KITTITAS COUNTY

MEMORANDUM

TO: Community Development Services
FROM: Taylor Gustafson, Environmental/Transportation Planner TG
DATE: April 23, 2019
SUBJECT: BL-19-00004 Suncadia Phase 3 Div 15 & 16 Public Works Review

JOB NO. 998-765-017-0002
DRAWN: C.A.F./R.F.G.
DATE: 2019-03-26
SHEET 1 OF 17

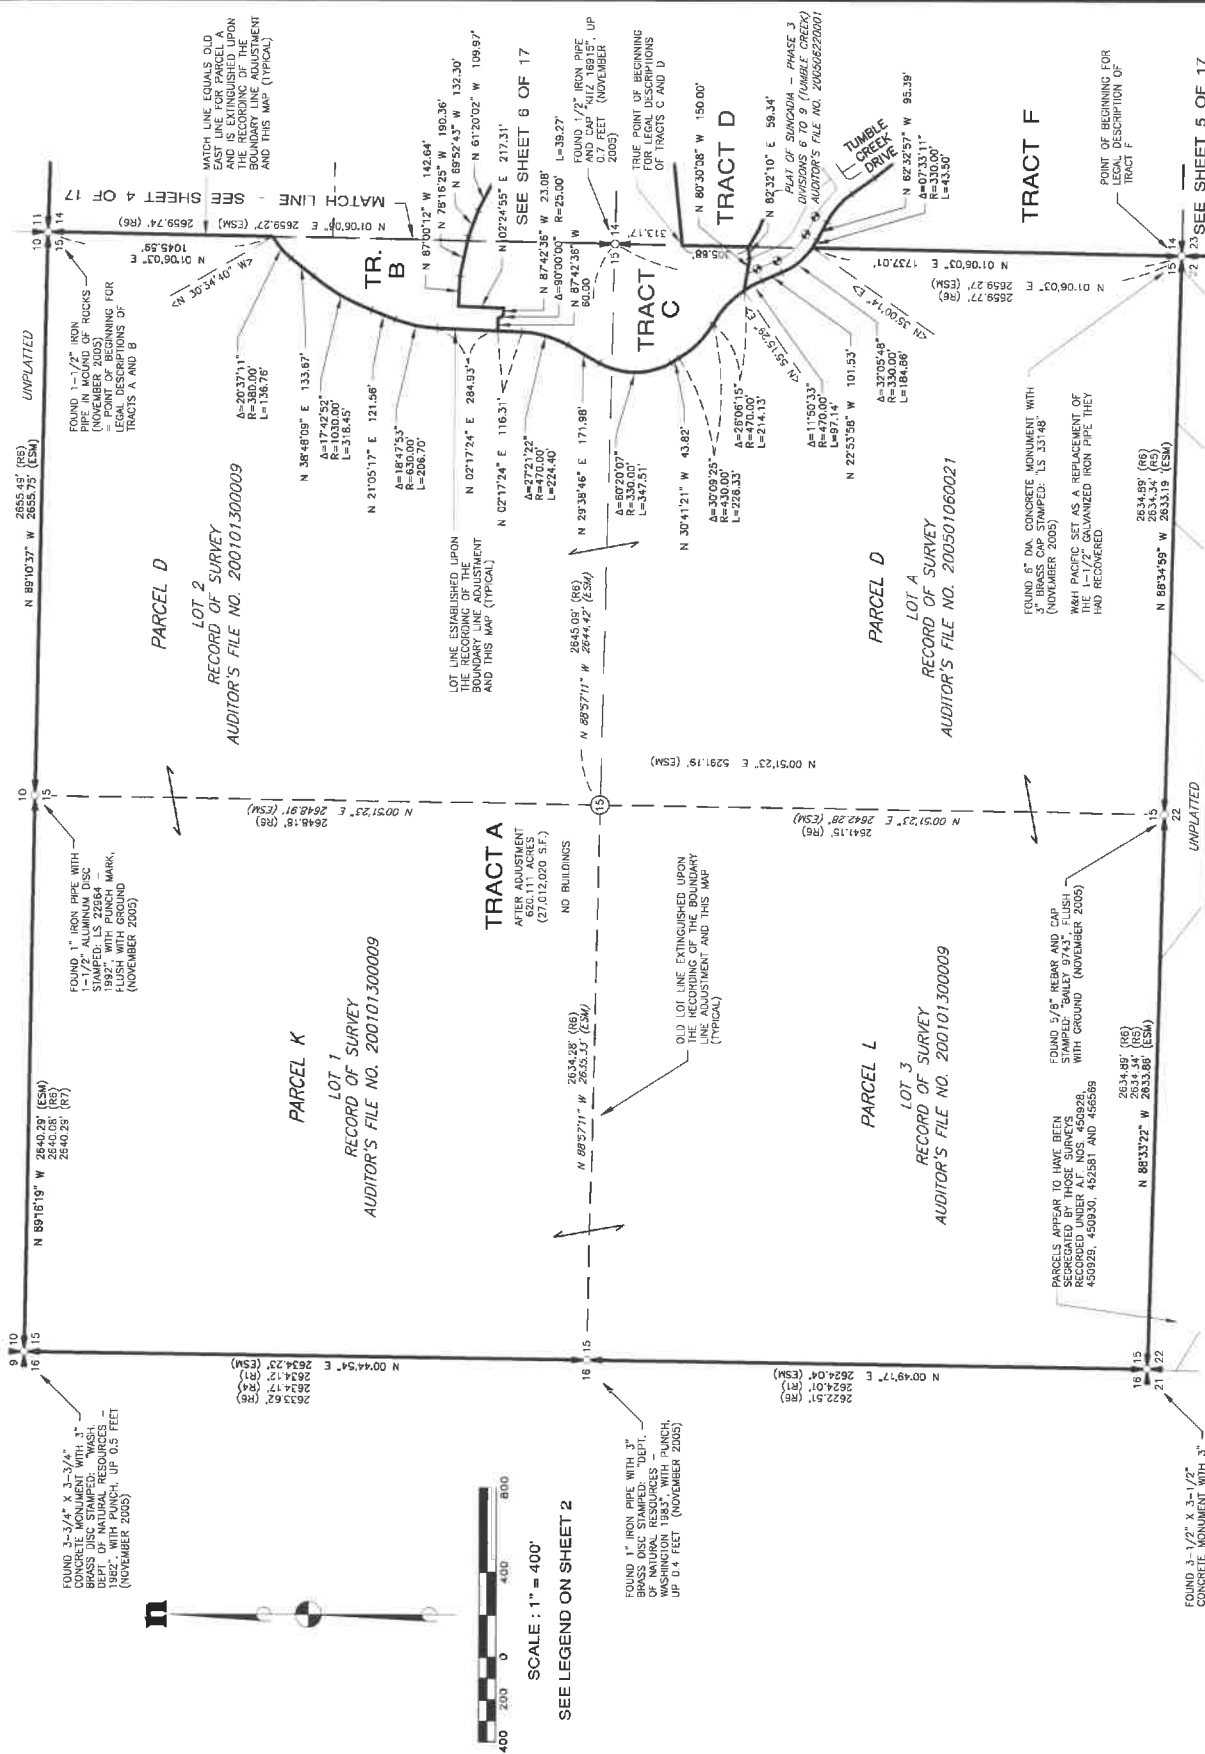
3. Note 1 about not setting corners, is typically not allowed.
I believe that the reason for not setting them is justified under RCW:58.09.020 for all lots under the ownership of New Suncadia, and under RCW:58.17.040(6) for Tract D.
If this is the intent, it should be noted.
4. The statement for Survey Instrumentation appears to have been cut off.
